INDEPENDENT EXPERT ADVISORY PANEL FOR MINING

***Moolarben Coal Stage 1:
Review of UG4 LW401, LW402, LW403
End of Panel Report – Groundwater
Monitoring***

February 2024

Report No: IEAPM 202402-1

Figure 4 Groundwater Monitoring Locations Relevant to Longwalls 401 to 408

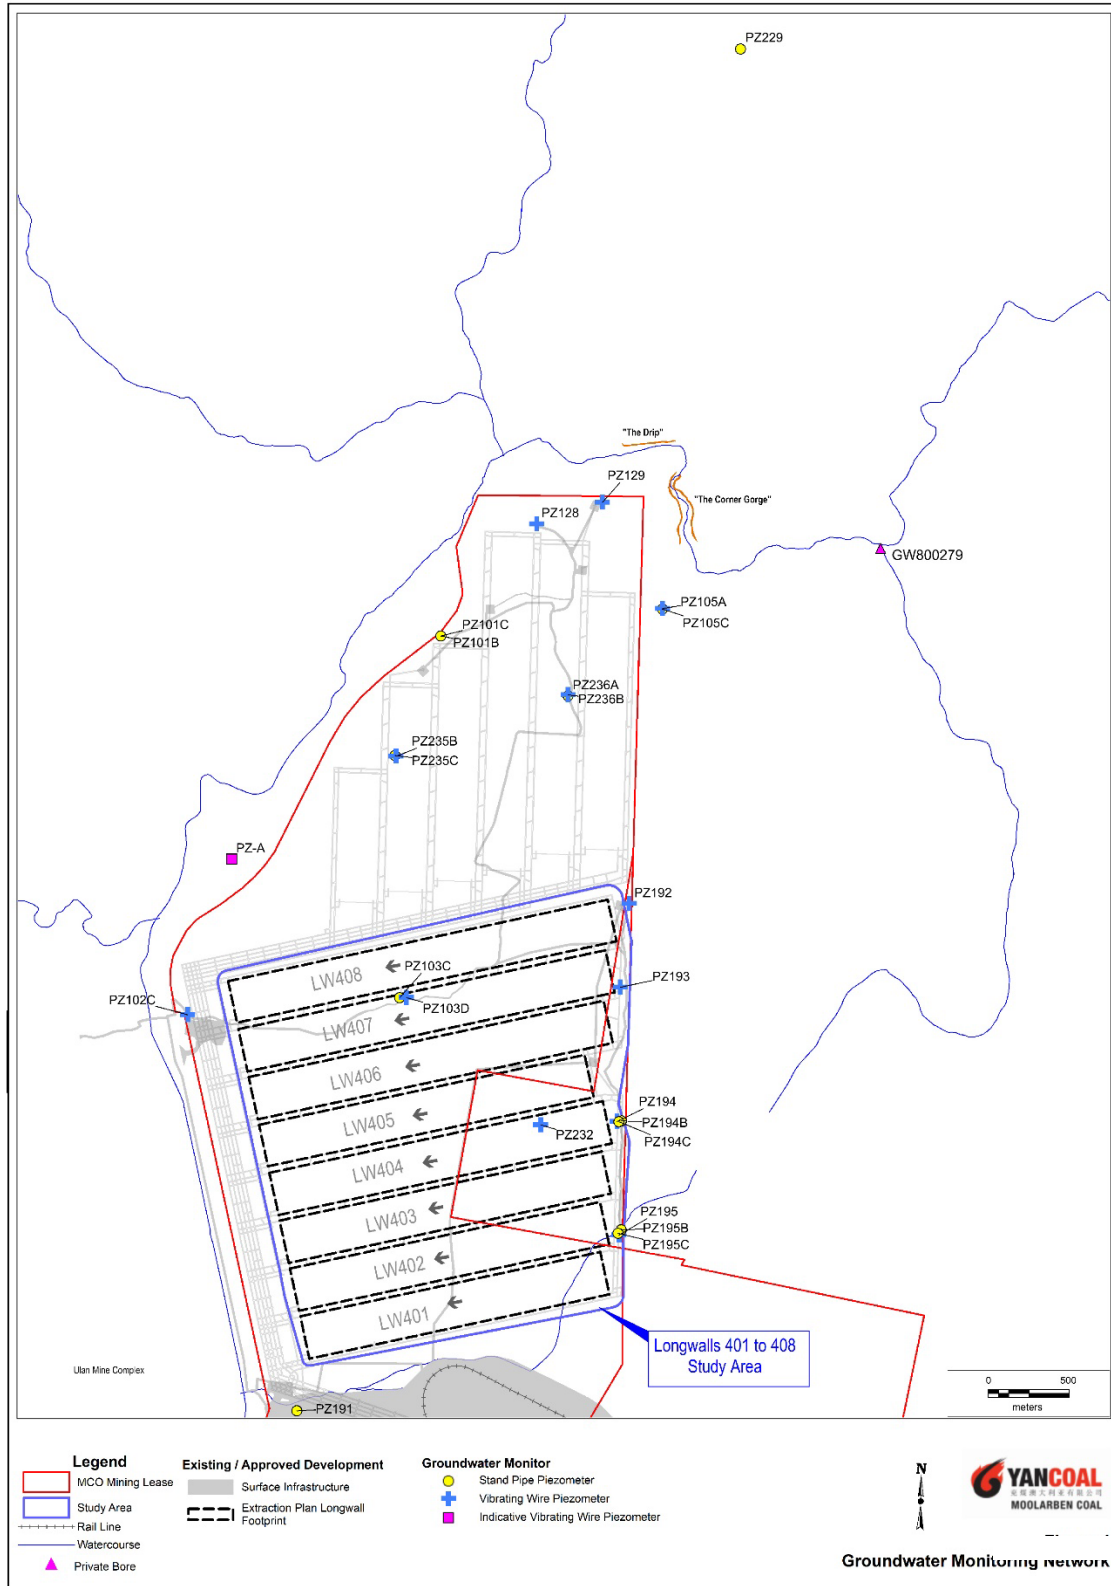
The current groundwater monitoring network is summarised in the EoP report (Table 2) which has been extracted from the current version of the Water Management Plan for UG4 (MCO 2023b, Table 6). The monitoring network described in Table 2 of the EoP is the most recent and reliable list as it is noted that standpipes PZ102A and PZ103A have now been decommissioned and replaced by VWP sensors at PZ103D, and one new site (PZ235C) is listed. The groundwater monitoring network map shown in Figure 1 of this advice (taken from AGE 2023) is slightly more comprehensive than the network map presented in the EoP report (Figure 4).

Figure 5 UG4 Triassic Sandstone Hydrograph

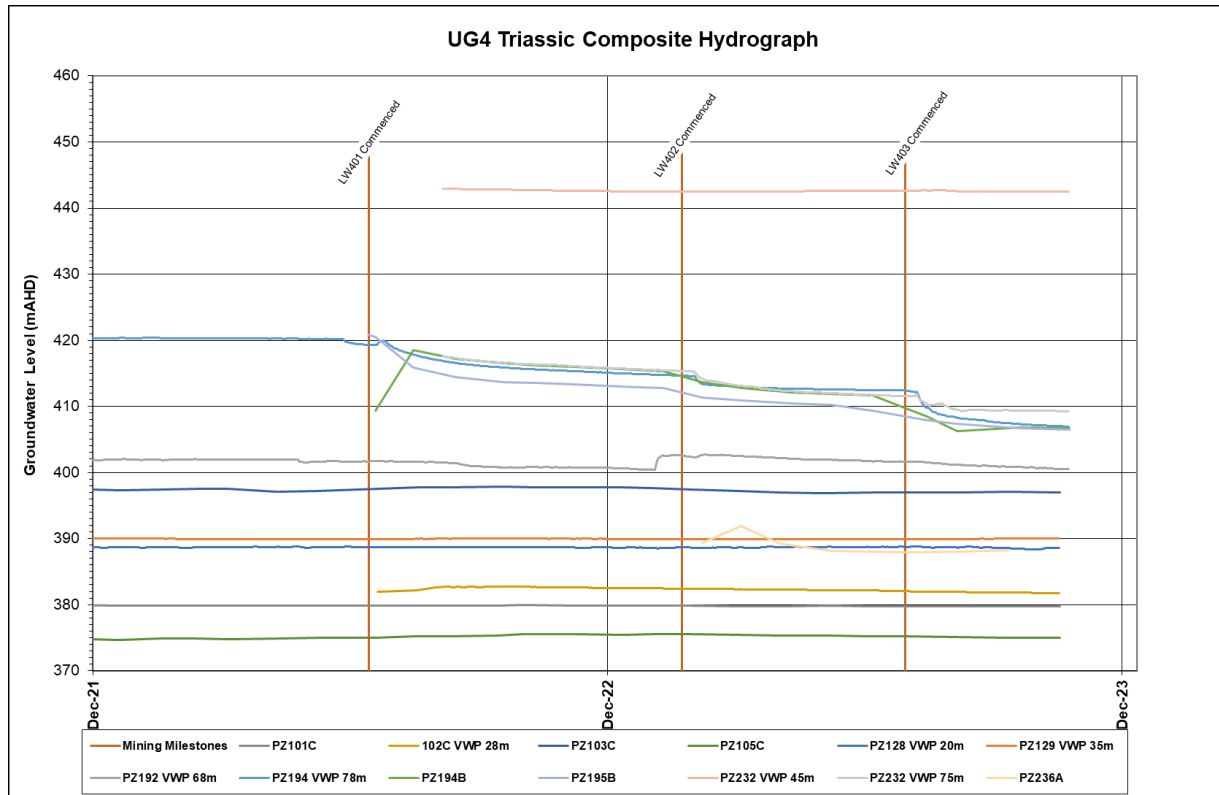
Figure 5 in the EoP report provides the composite hydrographs of most monitoring bores tracking Triassic sandstone water levels in the UG4 LW401 to 408 area. Individual water level trends are hard to differentiate in this Figure, so reference was also made to the individual hydrographs in Appendix A of AGE 2023. Mining-induced water level declines are evident at:

- PZ103C (standpipe) since the commencement of LW401 (less than 0.5m)
- PZ192 (VWP 68m sensor) since the commencement of LW402 (approx. 2m)
- PZ193 (VWP 80m sensor) since the commencement of LW402 (approx. 6m)
- PZ194B (standpipe) since the commencement of LW401 (approx. 11m)
- PZ194 (VWP 78m sensor) since the commencement of LW401 (approx. 12m)
- PZ195B (standpipe) since the commencement of LW401 (approx. 12m)
- PZ232 (VWP 45m sensor) since the commencement of LW401 (less than 1m)
- PZ232 (VWP 75m sensor) since the commencement of LW401 (approx. 6m)
- Potentially PZ236A (standpipe) since the commencement of LW402 (less than 2m)

Most of these sites are located within or adjacent to mined LWs401 to 403. The northernmost site where there is an observed drawdown in the Triassic sandstone is PZ192 (eastern boundary of LW408). The slight drawdown at PZ236A (LW413) could potentially be climatic. There is minimal drawdown in the Triassic strata to the north beyond LW408 towards the Goulburn River and ‘The Drip’ (based on data from five sites). No groundwater level investigations were triggered at the three nominated trigger locations in the Water Management Plan (MCO 2023b) during the extraction of LWs401-403.

The descriptive text in Sections 2.1.1 (LW401), 2.1.2 (LW402) and 2.1.3 (LW403) of the EoP report does not adequately describe the hydrographic trends in Figure 5. The text focuses on VWP sensors while there are confirmed declines in several standpipe locations as well. A spatial appreciation of the observed drawdowns in the Triassic strata since the commencement of LW401 would have provided an improved understanding of shallow groundwater impacts to date.

Figure 6 UG4 Permian Overburden Composite Hydrograph

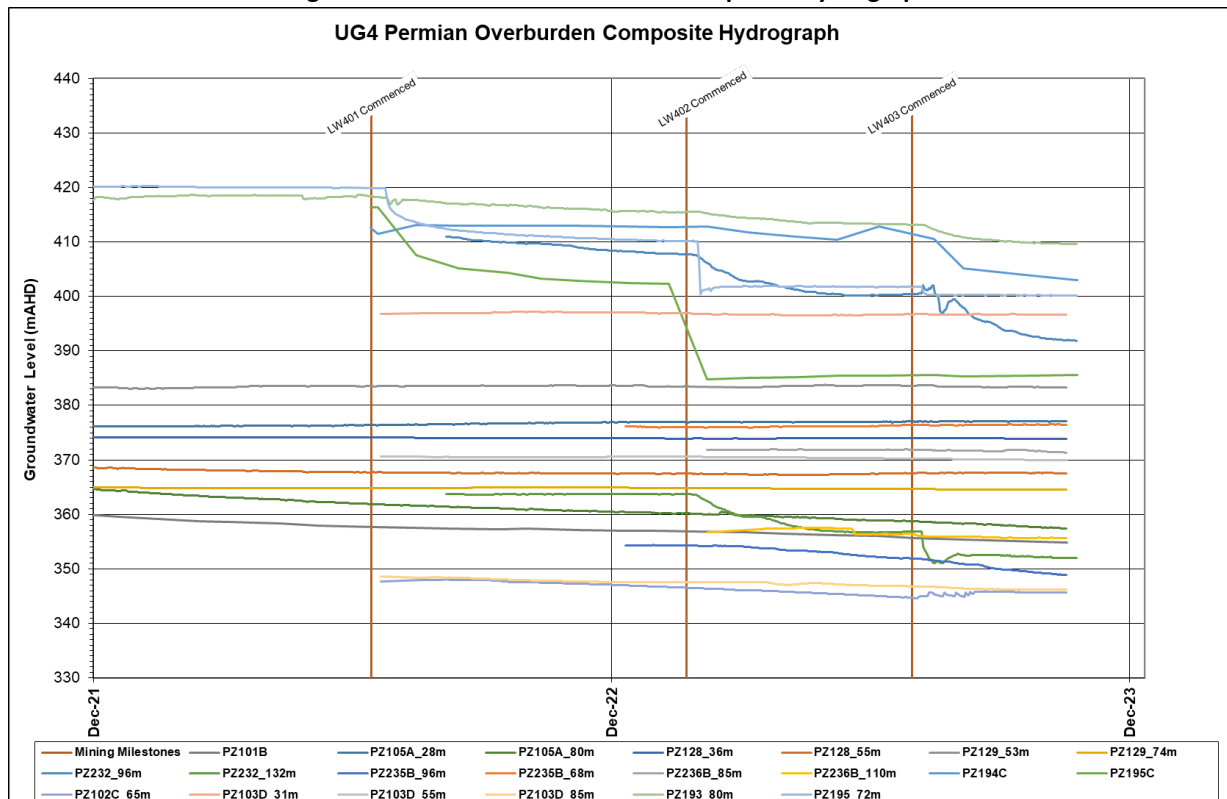
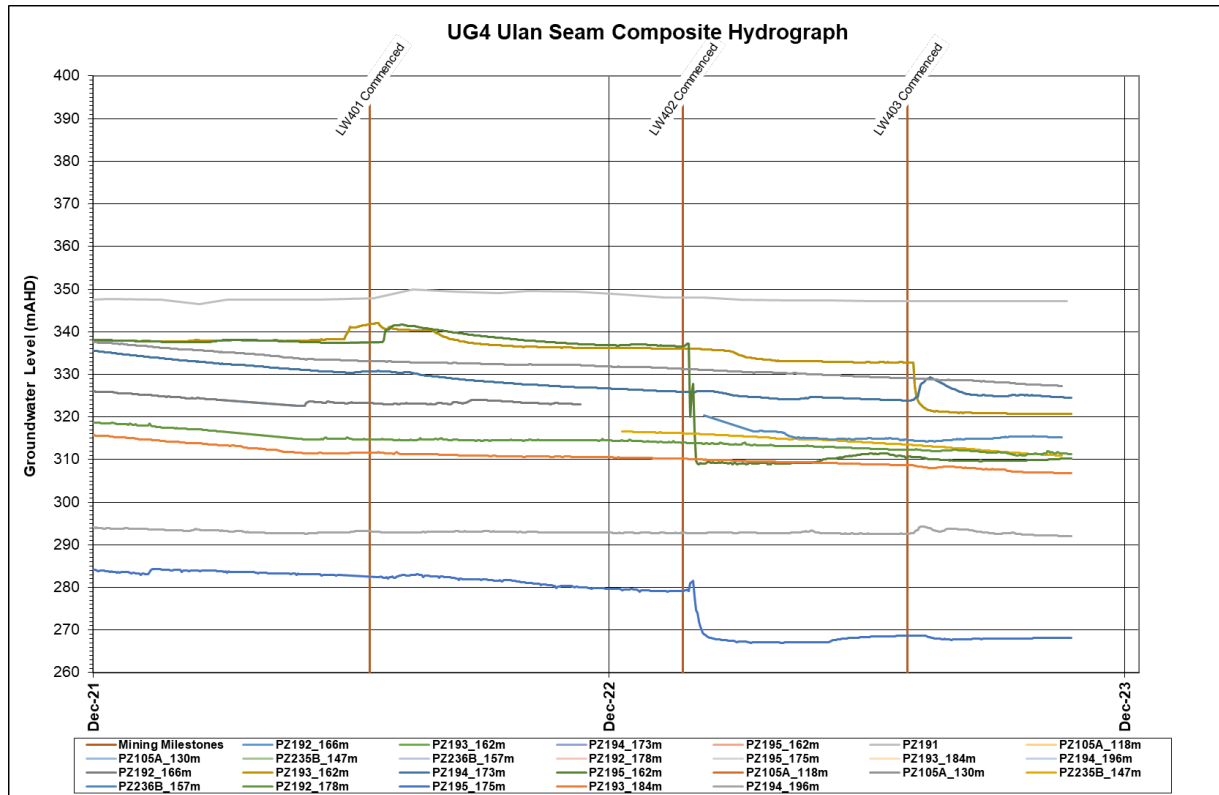
The composite hydrographs for the deeper UG4 Permian overburden and UG4 Ulan coal seam are presented in Figures 6 and 7 respectively of the EoP report. Again, water level trends are hard to differentiate in these composite Figures, so reference was also made to the individual hydrographs in Appendix A of AGE 2023. There are water level and pressure declines across most monitored standpipes and VWP sensors. Within and adjacent to the LW401 to 403 area since early 2021, there have been water level declines of 25-35m in both the Permian overburden and Ulan Coal seam groundwater systems and up to 60m of drawdown since 2014. Further north towards the Goulburn River and ‘The Drip’ there are measurable declines of up to 10m in the Permian overburden (standpipe PZ101B and VWP sensors at PZ105A, PZ128 and PZ129) and up to 25m in the Ulan Coal seam (deep sensors at PZ105A).

For the Permian overburden, there is a poor correlation between observed and maximum predicted drawdowns. The hydrographs clearly demonstrate extensive drawdown to the north of LWs401-408 which is the direct result of the extraction of LWs401-403. The model is only predicting between 2 and 5m of drawdown at the base of the Permian overburden north of LW408 which is substantially less the current observed drawdowns which are in excess of 20m.
